Case Officer: Gemma Magnuson

Applicant: Bicester Hotel, Golf and Spa

Proposal: Erection of new building to accommodate a new cafe, pro shop, indoor practice room, lockers and viewing gallery

Proposed plans and Elevations

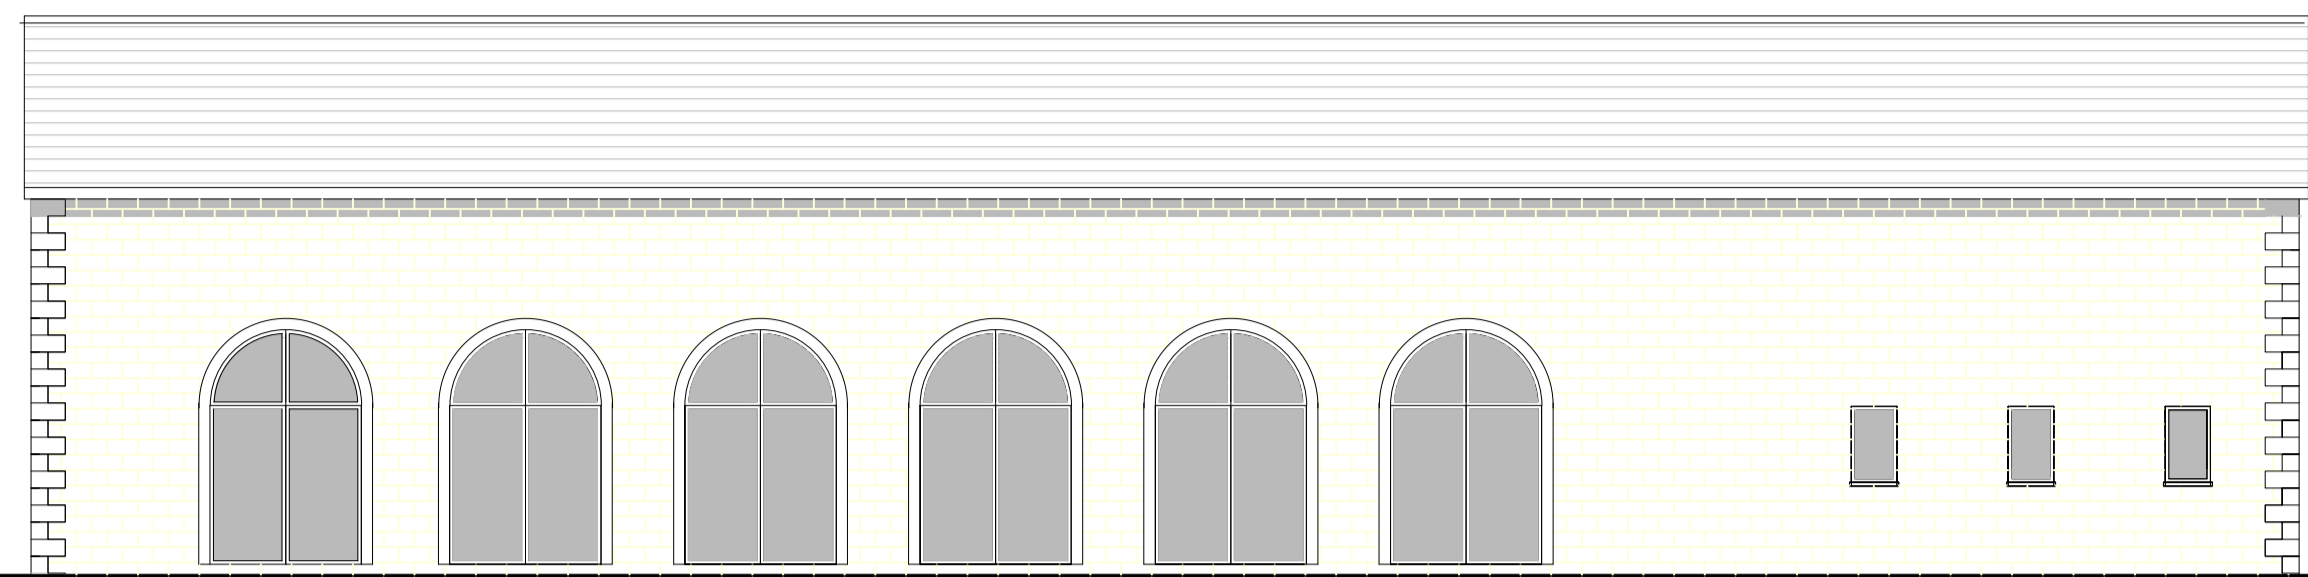
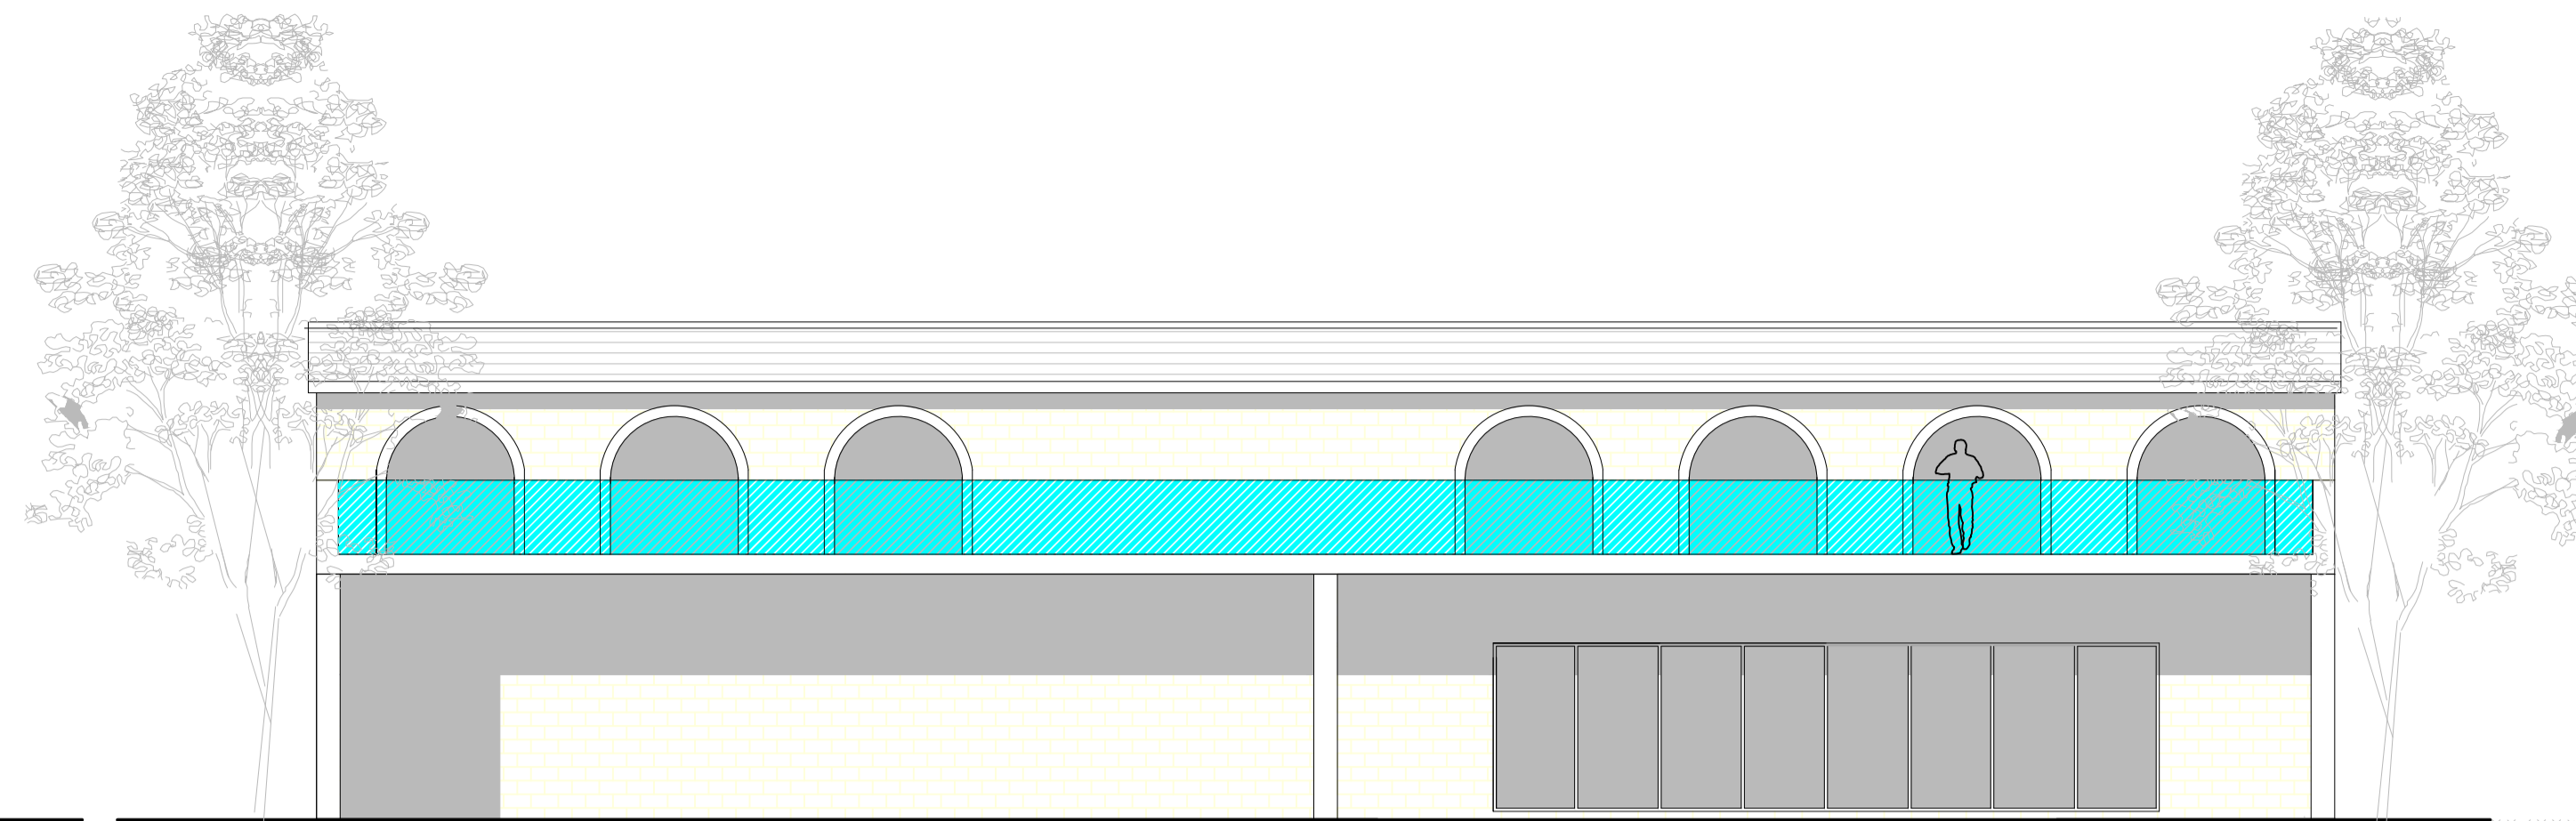
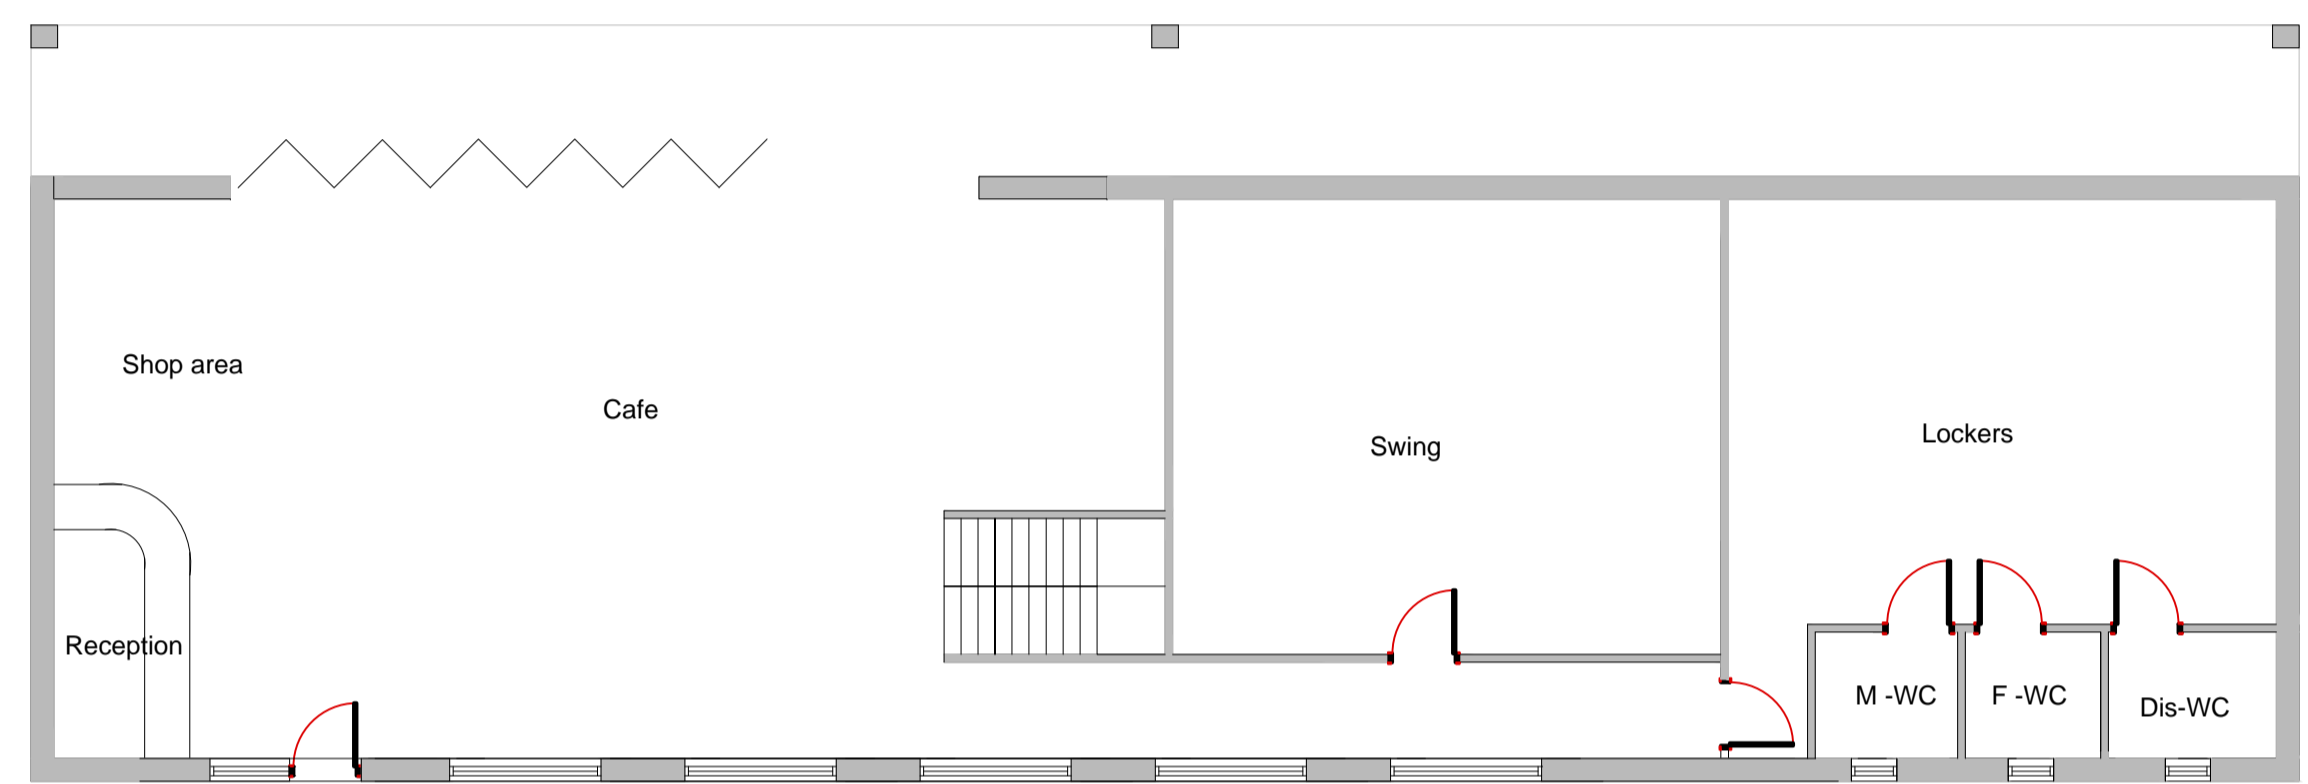
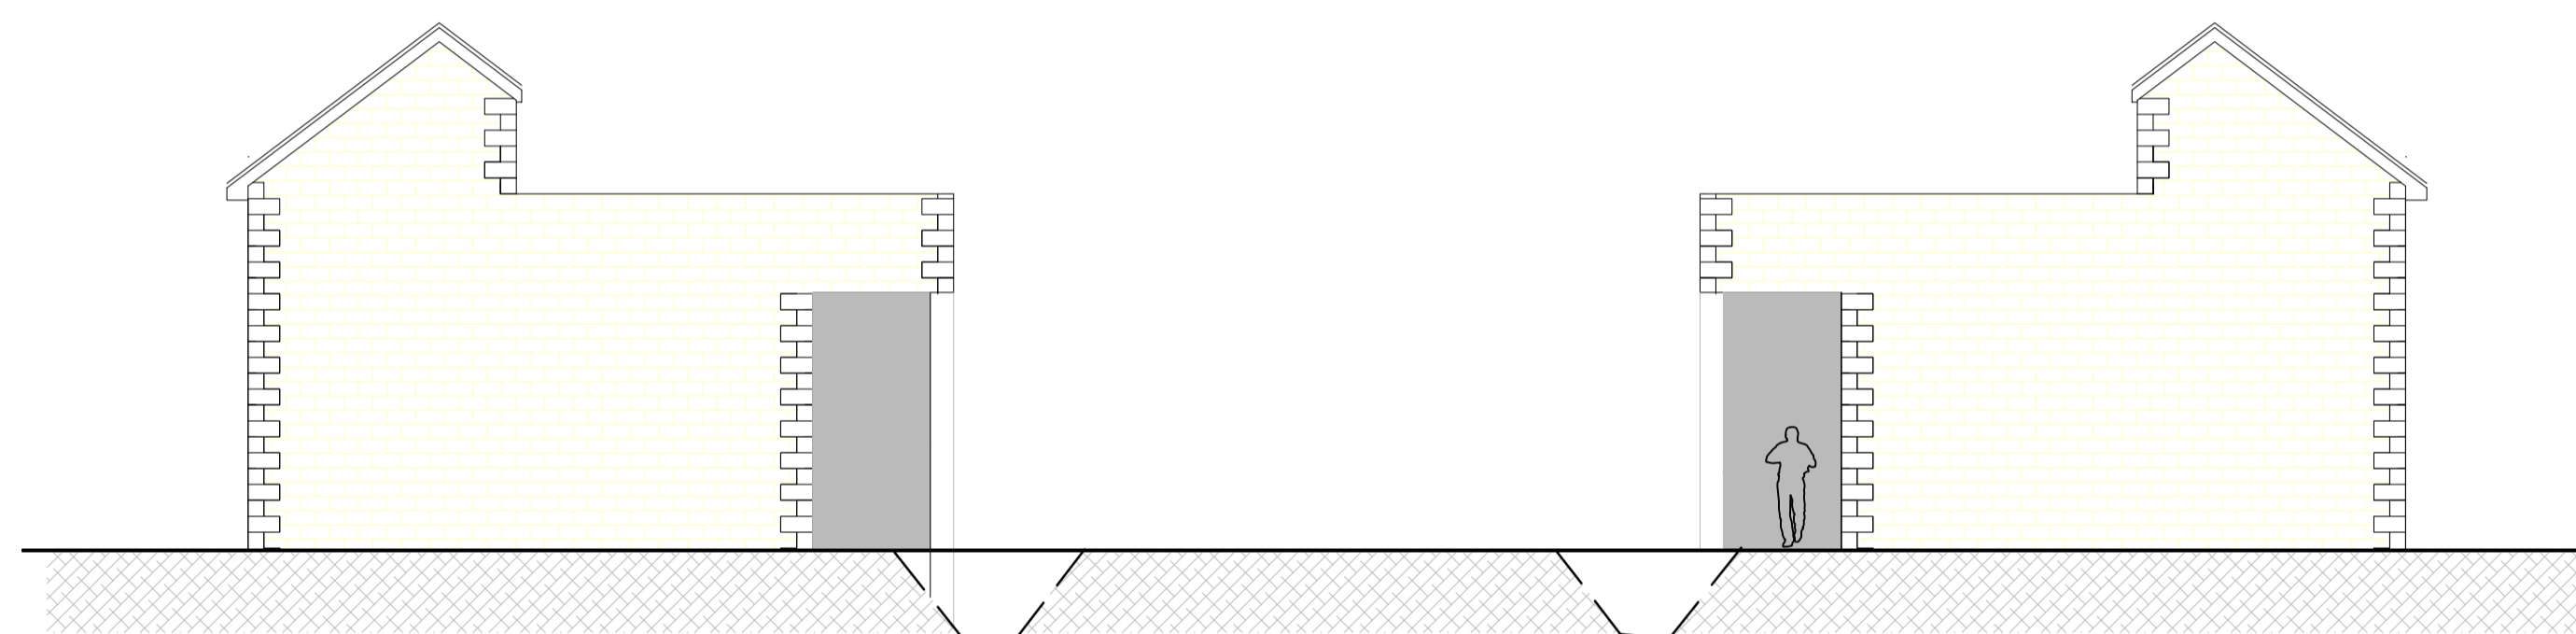
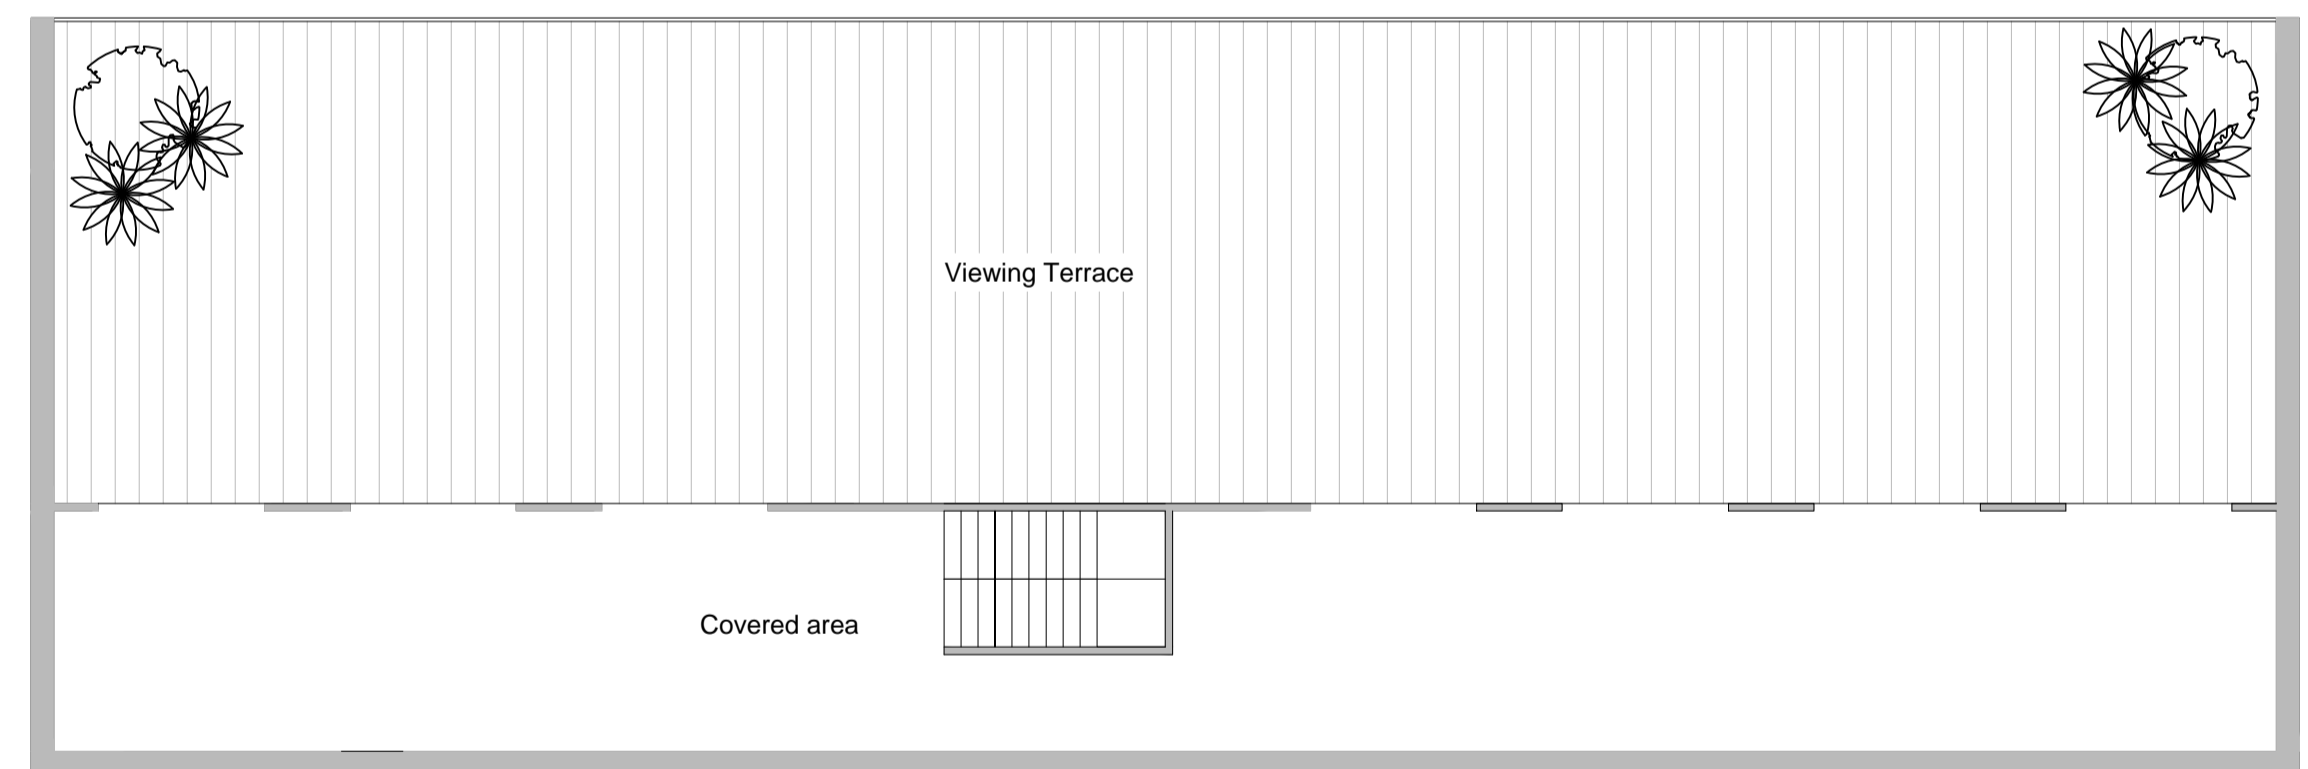
- 6.16. *Light: No comments*
- 6.17. CDC Rights of Way – no comments received.
- 6.18. CDC Licensing – no comment.
- 6.19. CDC Land Drainage - Drainage/Flood Risk. No comments additional to those already made in my response on 18/01/2022. The proposed building will be located over an existing ditch which must be retained, culverted or diverted to maintain continuity between upstream and downstream. If culverted, the culvert size must be consistent with the section of the ditch and anyway not less than 300mm diameter. A Land Drainage consent will be needed for any culverting in addition to any Planning Consent obtained. A Land Drainage consent application should be made showing details of the culverting including the headwalls at each end..

8.19. The original proposal included the infilling of the existing ditch, although the plans have since been amended to avoid this. The Land Drainage officer is content with the scheme and I have no reason to disagree with this. I therefore consider that the matter of drainage has been addressed and that the development would not result in an increased risk of flooding elsewhere, in accordance with the above Policies.
